State of Colorado )  
)ss  
County of El Paso )**Surveyor's  
Affidavit of Correction**

That I am a Licensed Professional Land Surveyor in the State of Colorado and prepared the Plat of Meadowbrook Crossing Filing No. 1, a subdivision of a tract of land situated in the south half of Section 8, Township 14 South, Range 65 West, of the 6<sup>th</sup> Principal Meridian, the said Plat of Meadowbrook Crossing Filing No. 1, having been recorded at Reception Number 218714112, of the El Paso County Records.

**Surveyor's  
Affidavit of Correction**

MEADOWBROOK CROSSING FILING NO. 1  
Drawn By: ZAR  
Checked By: SLM  
Date: 12/06/2016  
Sheet 2 of 3  
Project No. 160425

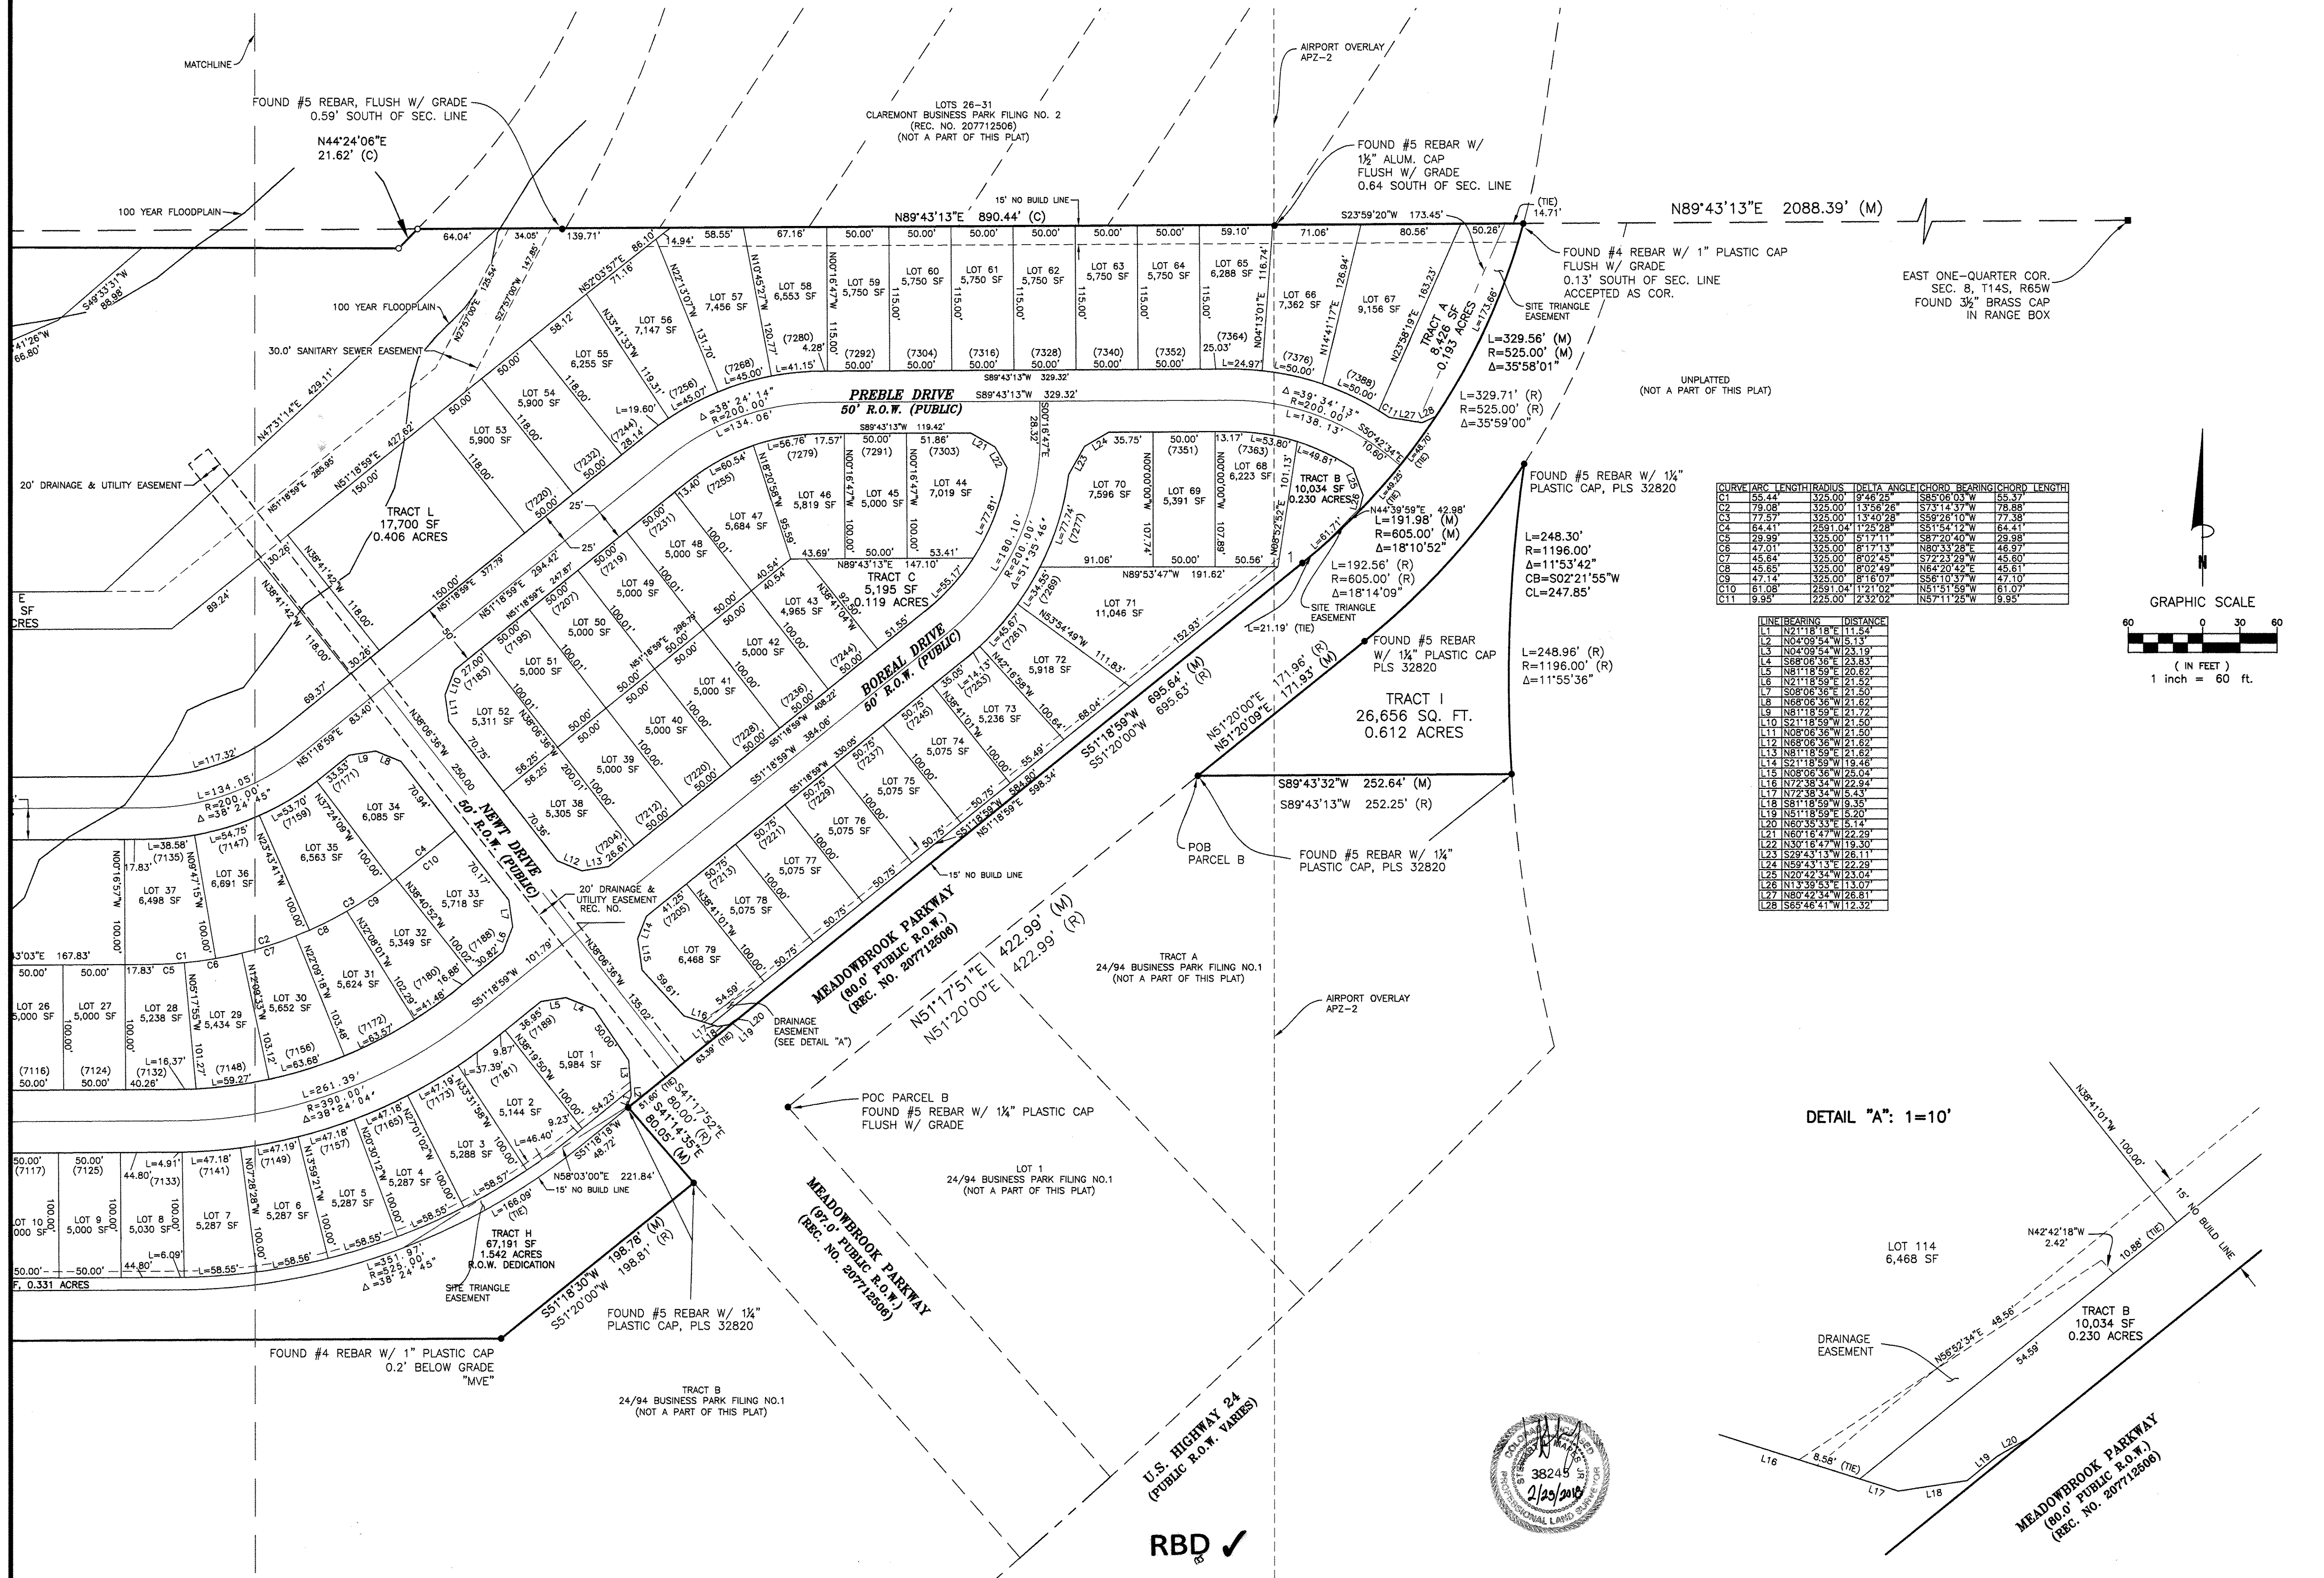
1. The exterior arc along the northwest intersection of Boreal Drive and Preble Drive has a recorded radius of 60.00', a central angle of 157°06'23", and a length of 164.53', and should have a chord bearing of N44°43'03"E, and a distance of 117.61'.
2. The exterior arc along the southwest corner of Boreal Drive, where it turns from the east and runs north, has a recorded radius of 60.00', a central angle of 157°06'23", and a length of 164.53, and should have a chord bearing of N45°16'57"W, and a distance of 117.61'.
